2005-0236
Application I. D. Number
10/12/2005
Application Date
Ruby Lane #14
Project Name/Description

RE: Application for Single Family Residences, Ruby Lane lots #13 and lot #14

Upon review of the site plans, the City's Planning Division has the following comments:

LOT 14 GRADING & EROSION
CONTROL PLAN

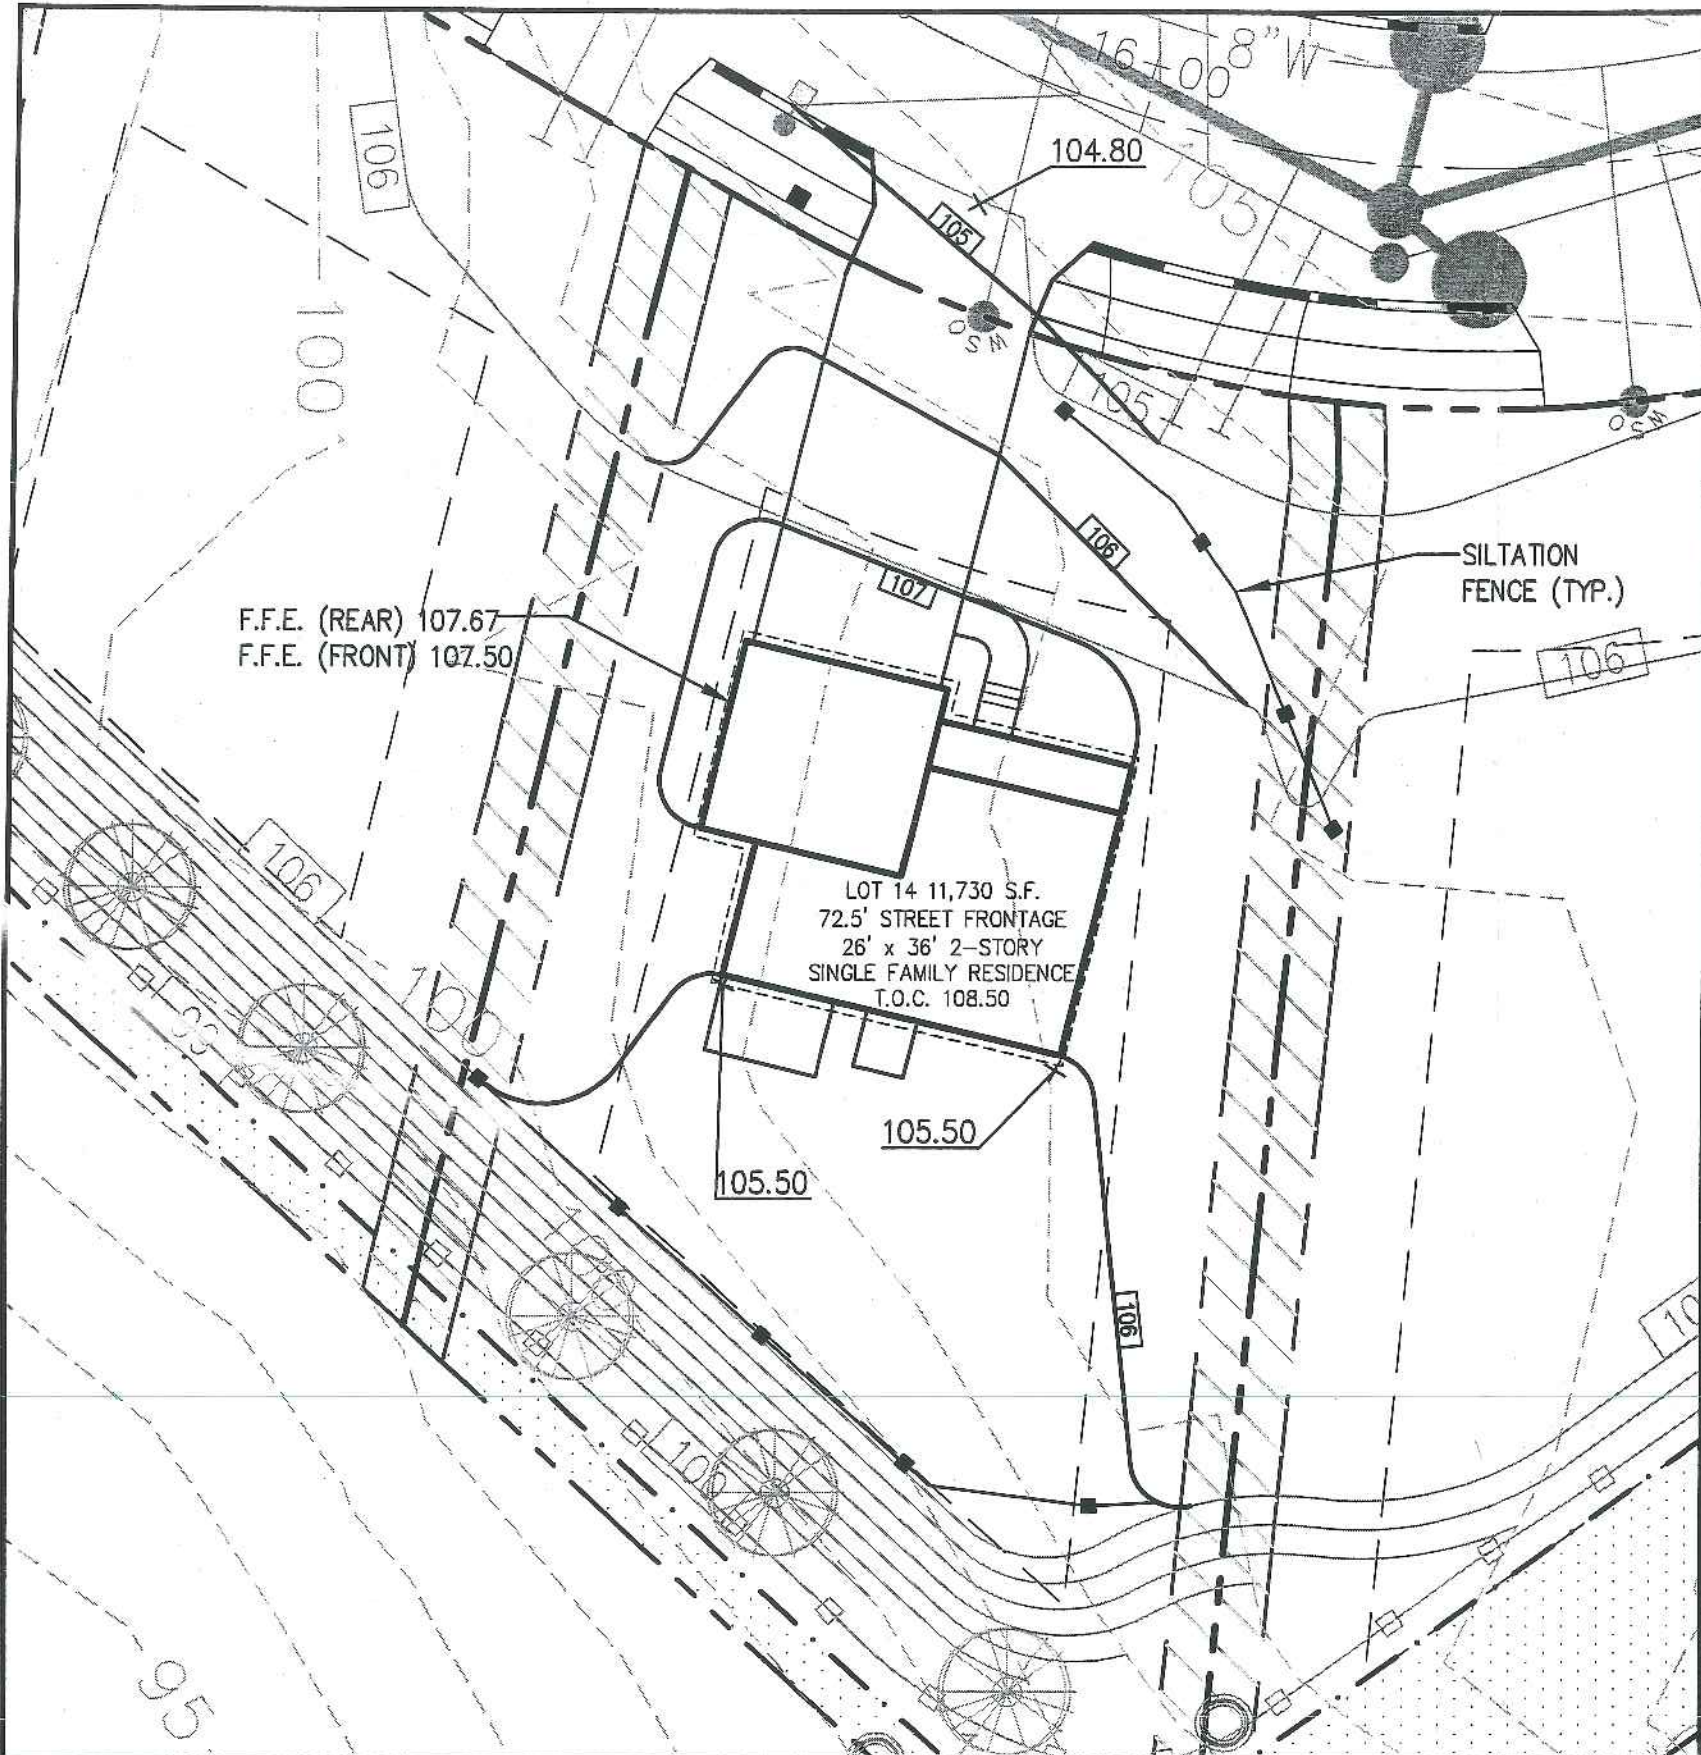
1. Please add two street trees to your plan.
2. Same items listed above (2., 3., and 4.).
